Alterations & first floor extension, providing a reduced garden room on the ground floor, together with conversion of garage to a gym & 2 new bedrooms, study & bathroom to first floor. Removal of existing pitched roof & replace with lower mono pitched roof

Sandgate House South Strand East Preston Littlehampton

Thank you for your internet representation made on 8th August 2012 which has been recorded as **an objection** with the comments as follows:

1207 SK23
Sandgate House, East Preston
First Floor As Proposed
June 2012
scale: 1:100

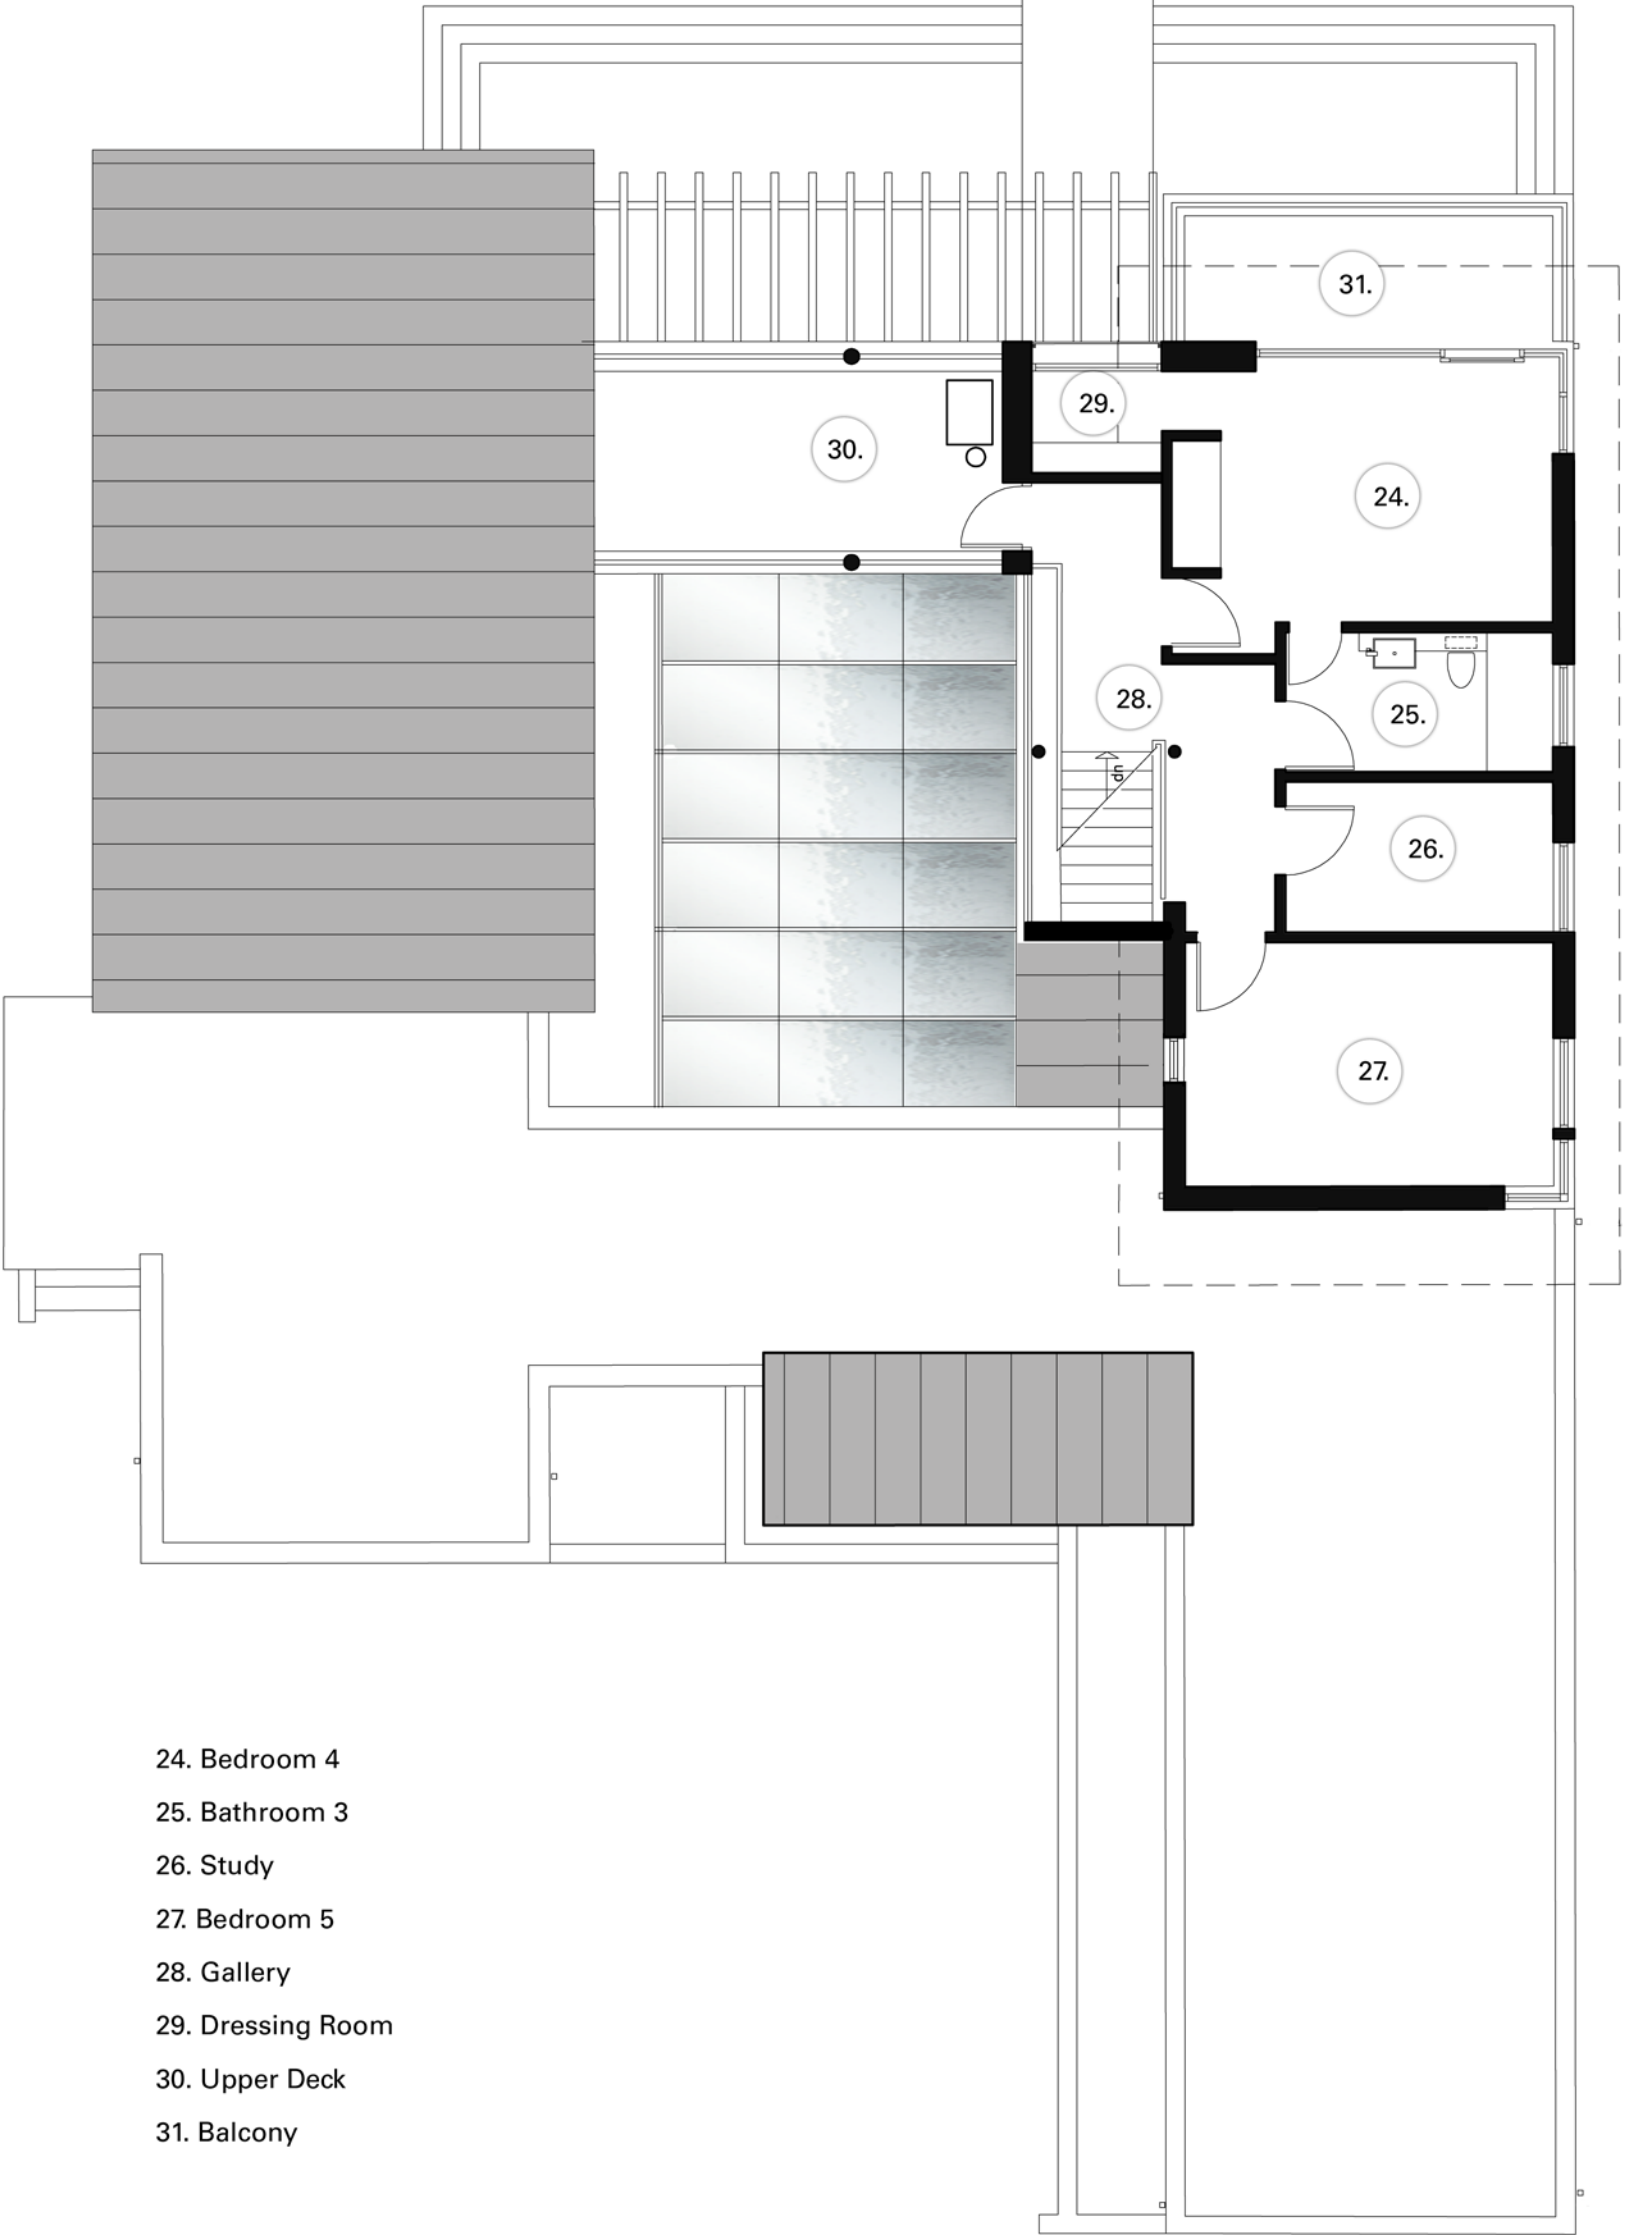
In addition, it would seem from the proposed plans that the dwelling will lose an existing garage with no plans to supply a replacement one. This could potentially have a negative effect on parking facilities for the property and could adversely affect immediate neighbours and other South Strand residents due to the existing parking restrictions on the Estate. □

1207 SK26
 Sandgate House, East Preston
 Elevations As Proposed - sheet 2
 June 2012
 scale: 1:100

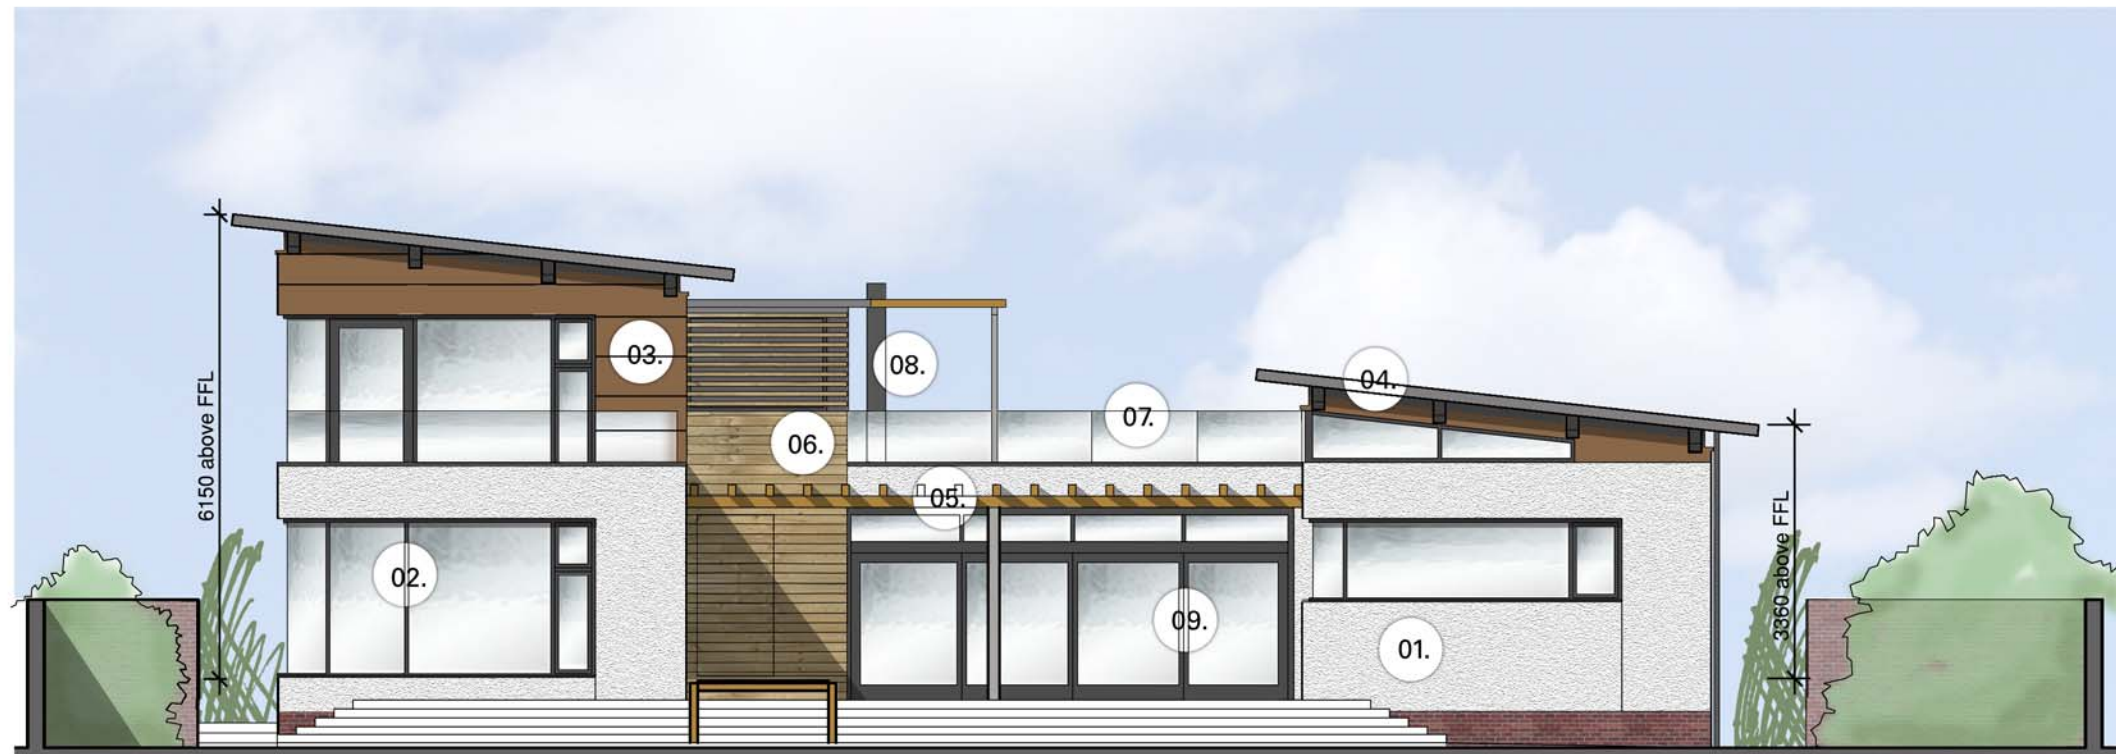
As the pictures in this application clearly show, this property has a prominent position on the East Preston Beach front and this plan of development is not in keeping with the current scene, nor the general scene of the Angmering on Sea Estate. □

a. Limit new building to heights not specifically greater than those of existing buildings. □

b. Design of new buildings should harmonise with existing buildings. □

d. Rendered walls in the Angmering-on-Sea Estate should be preserved on new buildings and extensions. □

1207 SK25 A
Sandgate House, East Preston
Elevations As Proposed - sheet 1
June 2012
scale: 1:100

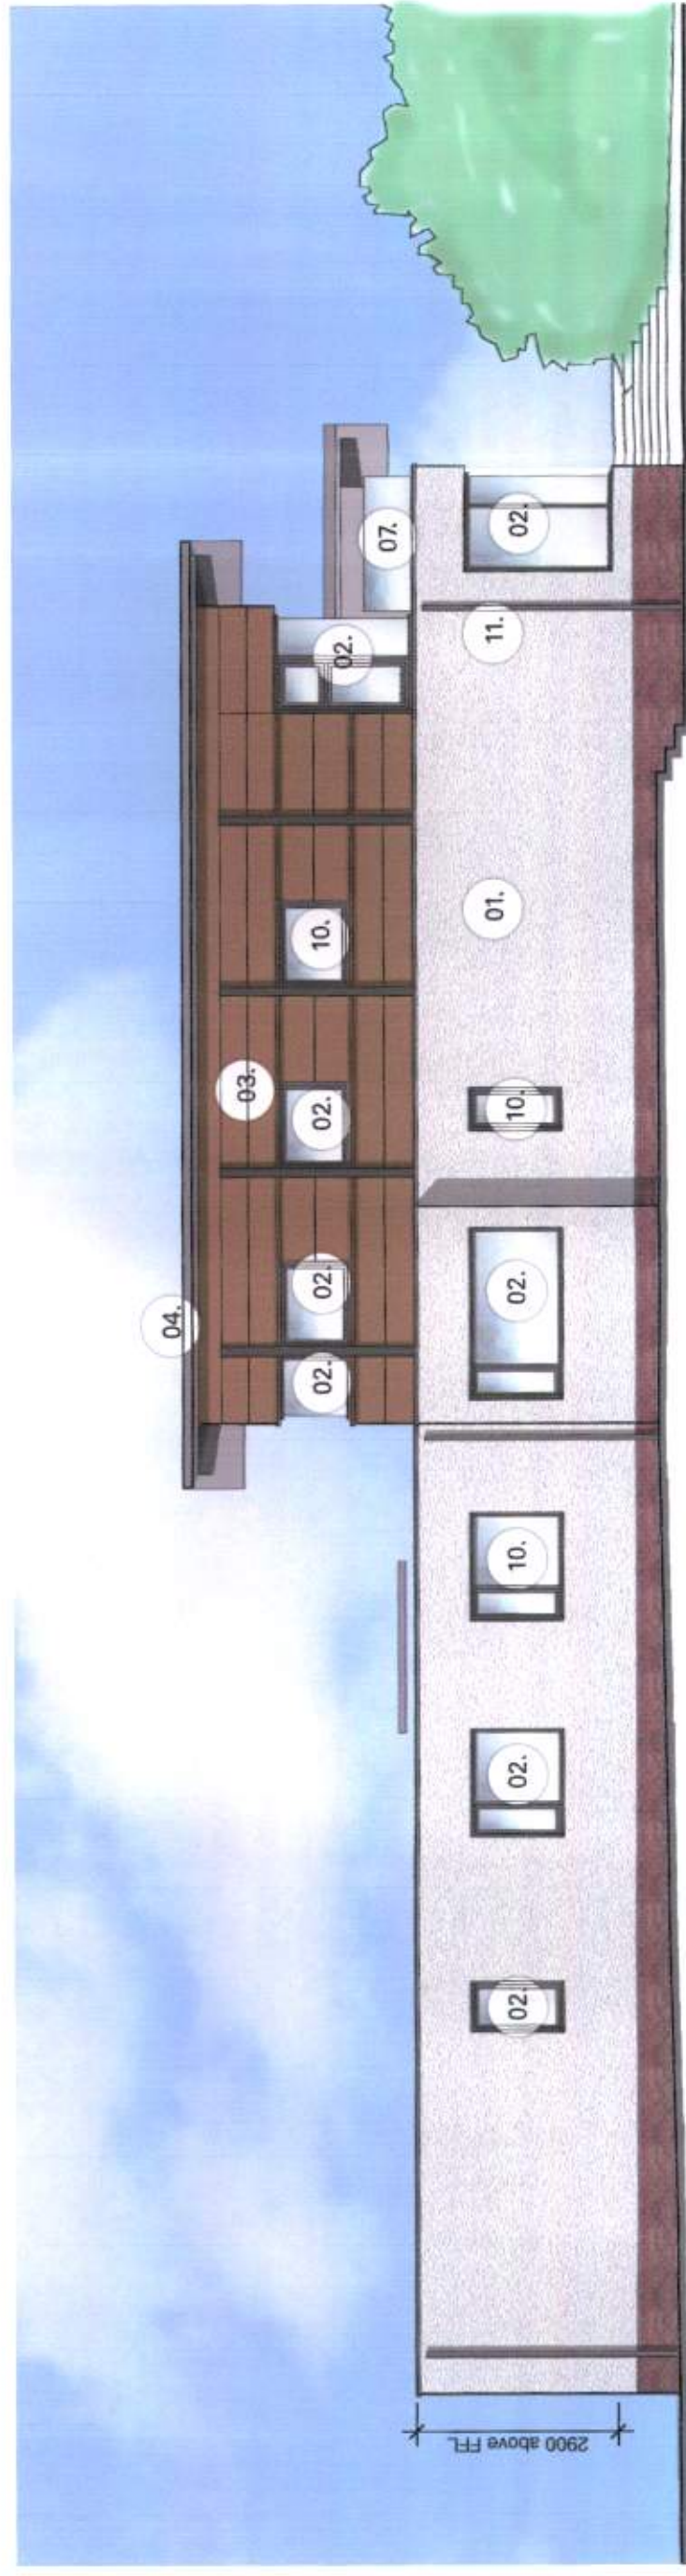
In our view the proposed extension does not comply with Policy DEV19 because the design of the proposed extension is not sympathetic to the existing building, it is not visually integrated with the existing building and its form and scale are not well-related to the existing building. Why would ADC Planning give their permission for more ghastly and uncharacteristic wood-clad New England (USA) style houses to be built on an Estate which is situated in West Sussex? □

i. the extension sympathetically relates to and is visually integrated with, the existing building in siting, design, form, scale and materials; □

ii. the extension is visually subservient to the main building; □

iii. the extension does not have an adverse overshadowing, overlooking or overbearing effect on neighbouring properties; □
